FINAL PLAT HUNSINGER SUBDIVISION

A VACATION AND REPLAT OF LOT 10, BLOCK B, AMENDED PLAT OF SPRING CREST AND OF
LOTS L AND K, BLOCK B, FILING No. 2 OF SPRING CREST
LOCATED IN A PORTION OF THE NORTHWEST QUARTER OF SECTION 28,
TOWNSHIP 12 SOUTH, RANGE 66 WEST OF THE 6TH P.M.,
EL PASO COUNTY, COLORADO

PCD FILE NO. VR-18-014

Markup Summary

AS REPLATTED

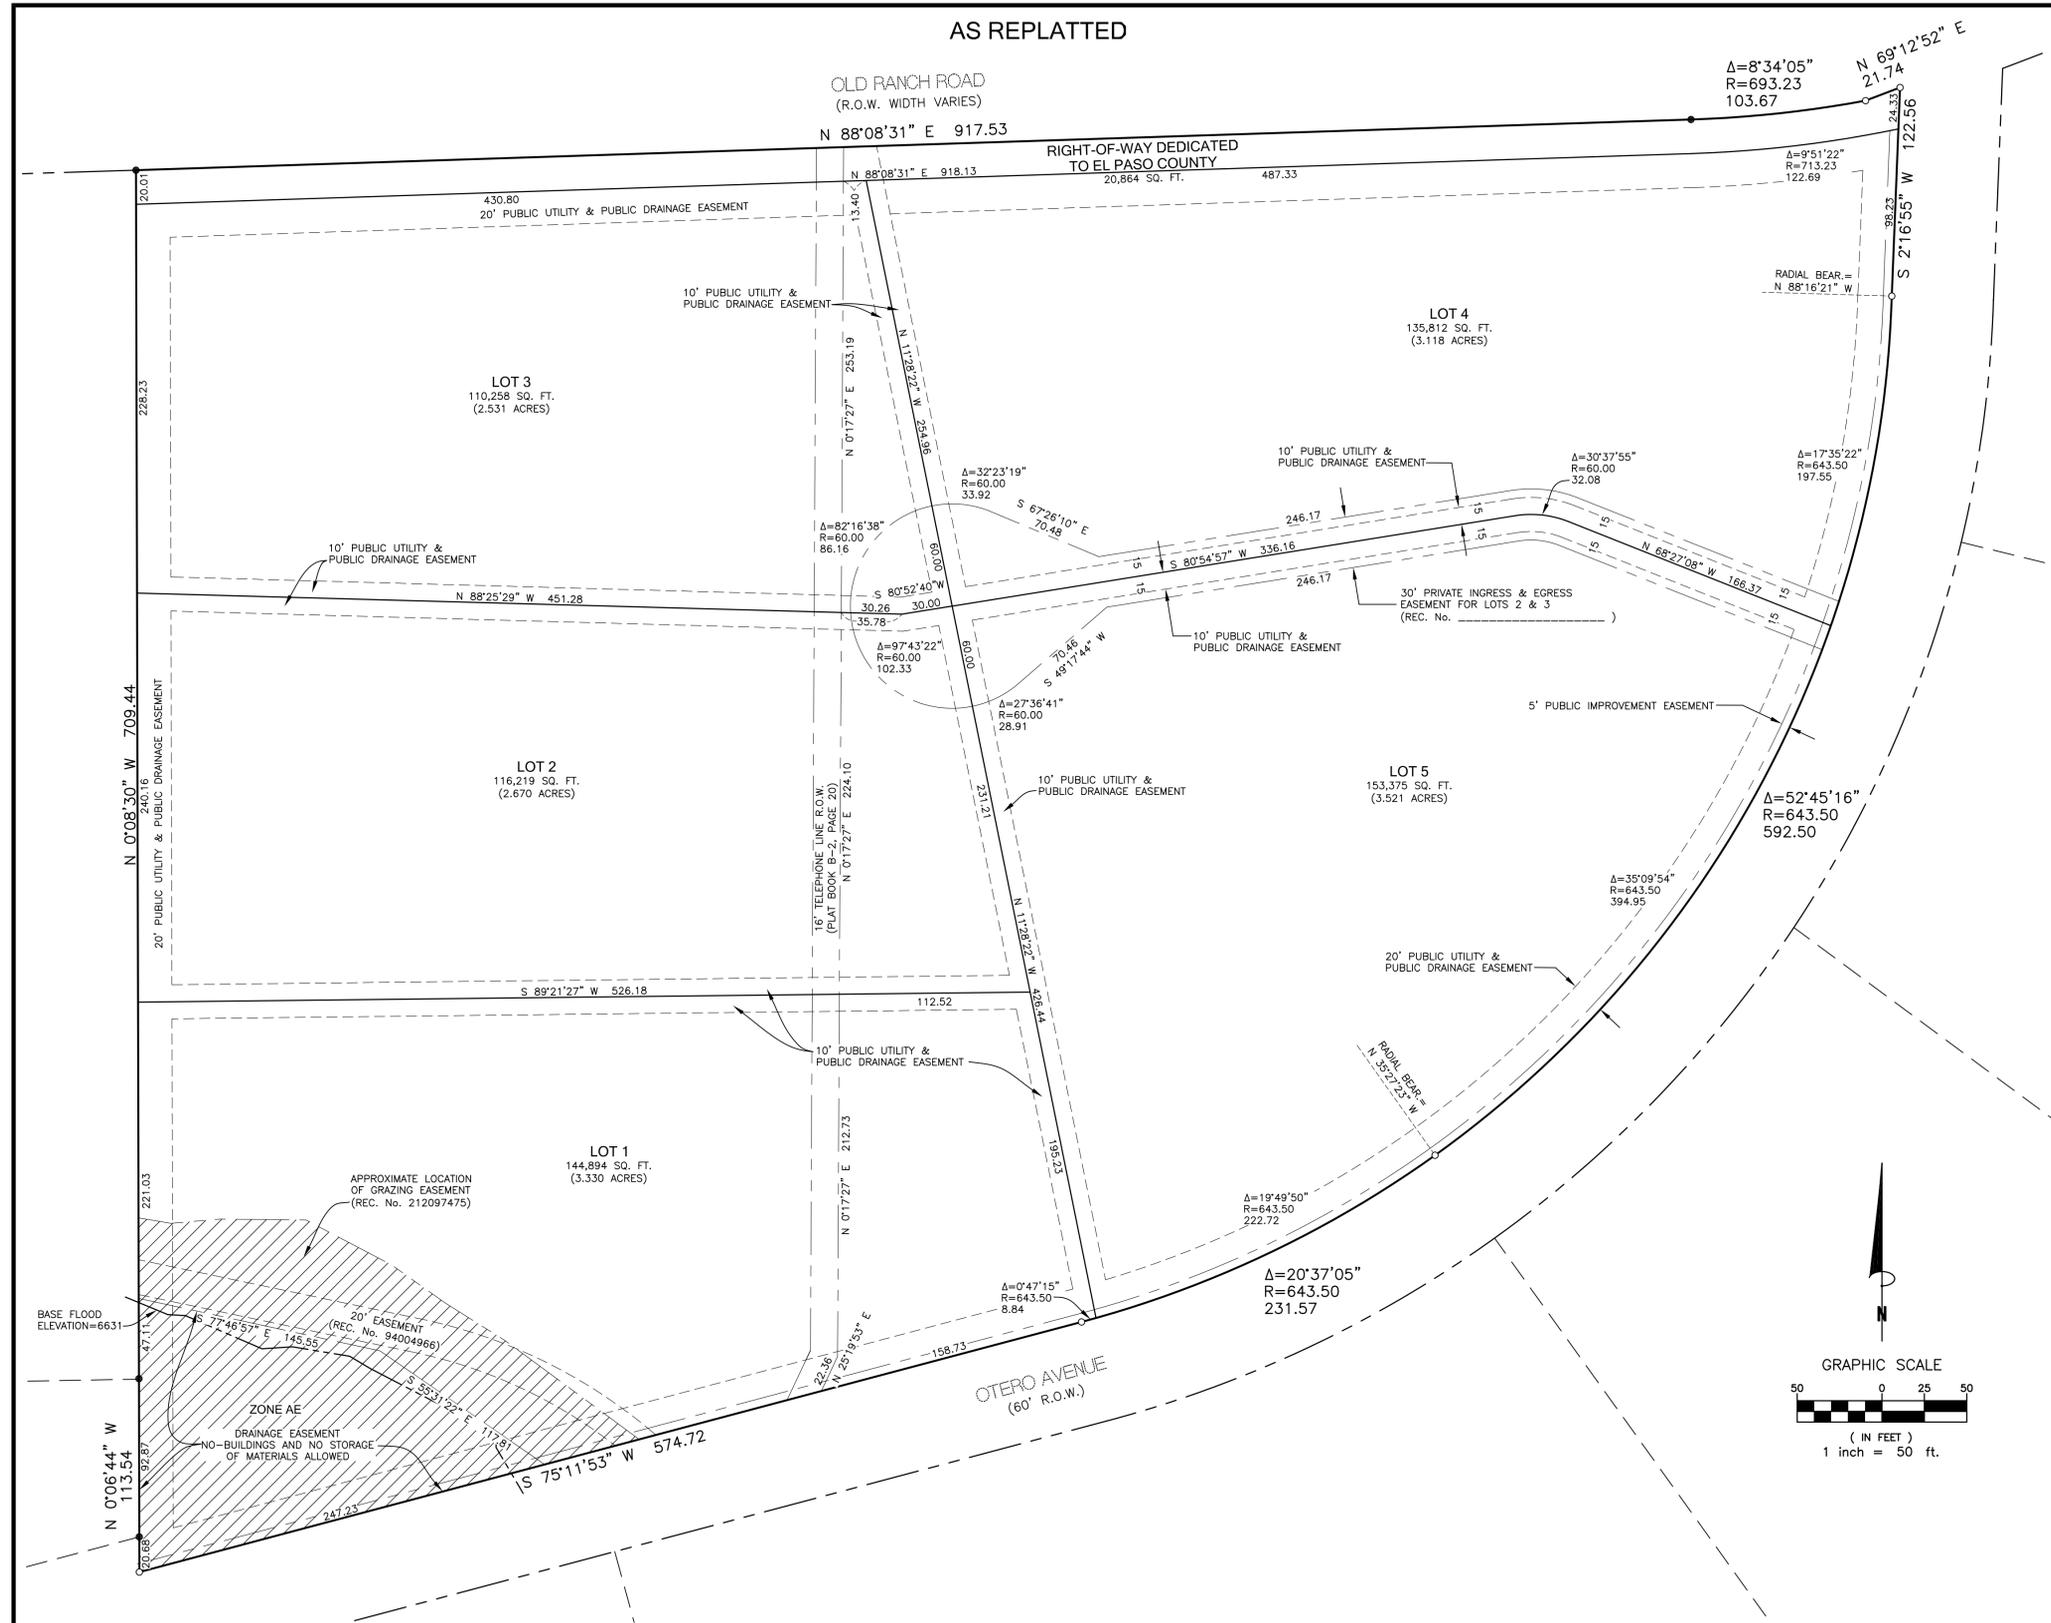
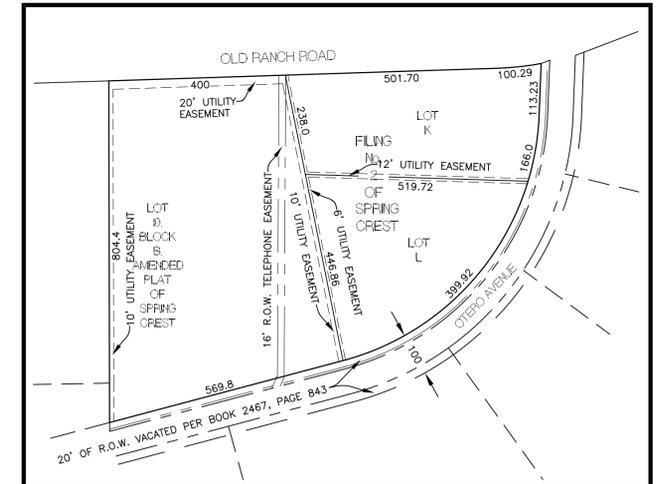
Add scale for the As-Platted
